# Memo.

**Subject:** S6/2011/1994/MA – Land at Salisbury Square, Hatfield

**Redevelopment of Salisbury Square; demolition of existing shopping parade building with 7 maisonettes above including retaining wall structures; construction of new road and layout of public spaces; erection of new building containing 19 flats and 4 shops with basements; new two level car park; erection of terrace of 5 houses with road and footways; access alterations, drainage and all ancillary works**

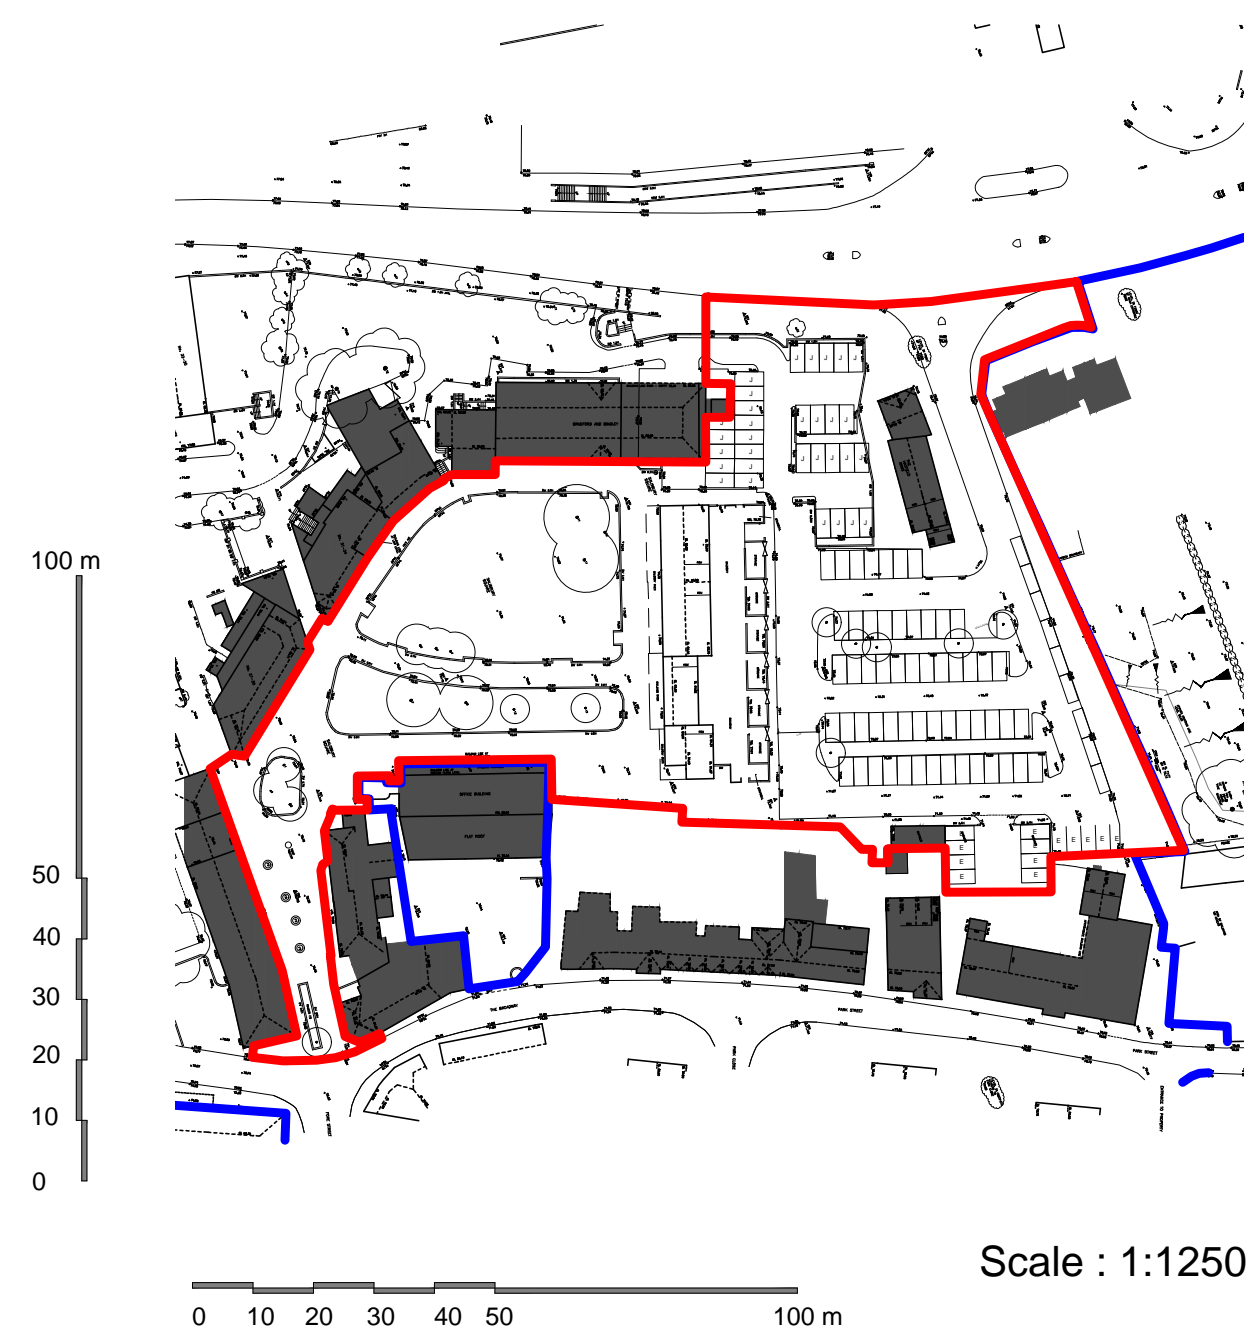
No landscape plan has been submitted but the suggested tree planting on the site plan concentrates on numbers rather than long term size or stature. The tree species should be the largest stature tree for the locations. Planting locations should also be identified to the entrance of the job Centre car park and within Salisbury Square.

The proposal does not indicate any additional landscaping. The area adjacent to, and north of, York House, within the site, will need some sort of softening with the use of landscaping. These details will need to be submitted to the Council for approval.

Details of the bed design east of Unit D should be submitted to the council for approval.

Our main concern was the proposed Salisbury Square. It has been designed as a sea of hard standing with a handful of trees and some parking. The LA considers that the use of a single level, with no kerbs, area is a useful and practical space. However, the same effect and practical space could be achieved whilst using grass and large crowned trees. I would agree with the use of large crowned trees in this area as a solar shade reducing the urban heat island effect, reduce the amount of rain runoff, dampen noise and soften the look of the area. Point 2.20 of the Design and Access statement notes that residents expressed a strong desire for a safe, welcoming environment, with more flexible and useable space. The use of some soft landscaping could achieve this.

The layout and design of the proposed Salisbury Square does give us cause for concern. As this is an integral part of the development this concern should be addressed before we commit to the landscape.
